Conservation officer consultation response

AB/125/20/L

Listed building consent for a single storey rear extension and alteration to existing kitchen roof.

19 Maltravers Street, Floorplan

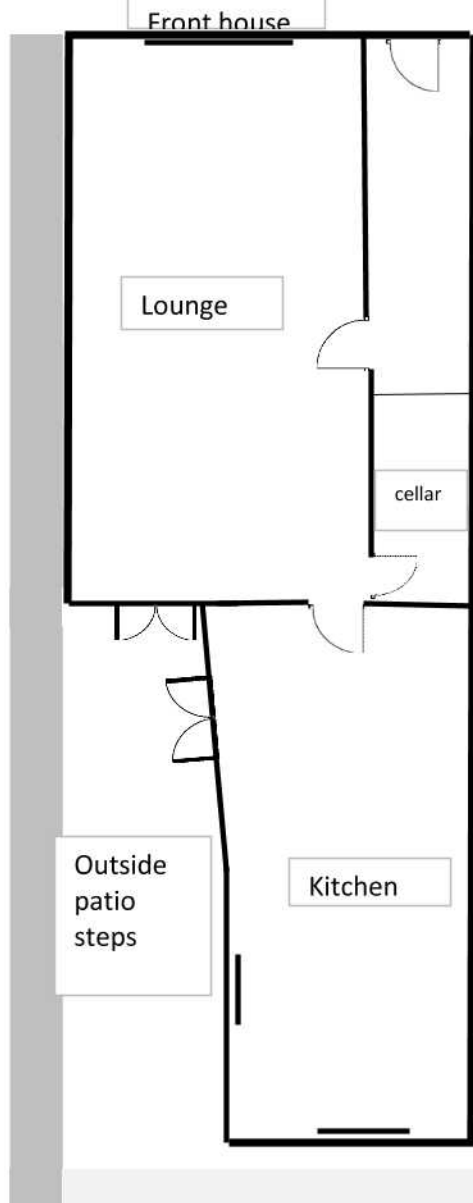
I also note that the intention is to replace an existing interior door with a window and remove a stretch of wall (so as to provide for a later kitchen space). Whilst the loss of historic fabric is unfortunate, the amount (and age) is such that to would not be detrimental to the building in this instance. The replacement of the door with an internal window is acceptable, subject to details of the design.

Elevation view 19 Maltravers Street, Arundel, BN18 9AP

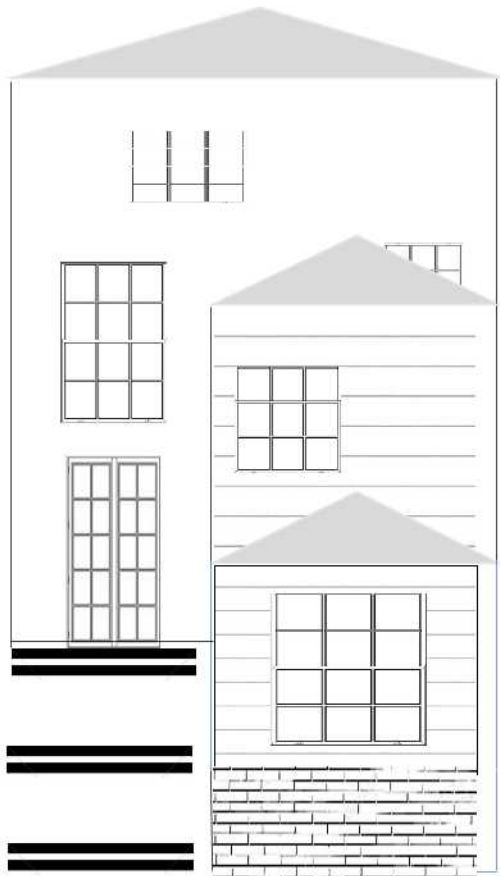
However, the level of detail that is provided as part of the application is limited. For instance, it is not clear how the junction between the elevation of the extension and the flat roof will be treated; will there be a parapet, or will bargeboards be used? Whilst reference is made to the use of bricks, it is not clear what these will look like, nor if any particular bond will be used so that the extension will reflect the age/character of the host building. Likewise, there are no details provided regarding the window to be used (materials, colour, glazing).

- Details of how the junction between the elevation of the extension and the flat roof will be treated
- Details of the brick and brick bond
- Details of the new external door including its materials, decorative/protective finish and method of glazing
- Details of the rooflight
- Details of the internal window, including the proposed glazing
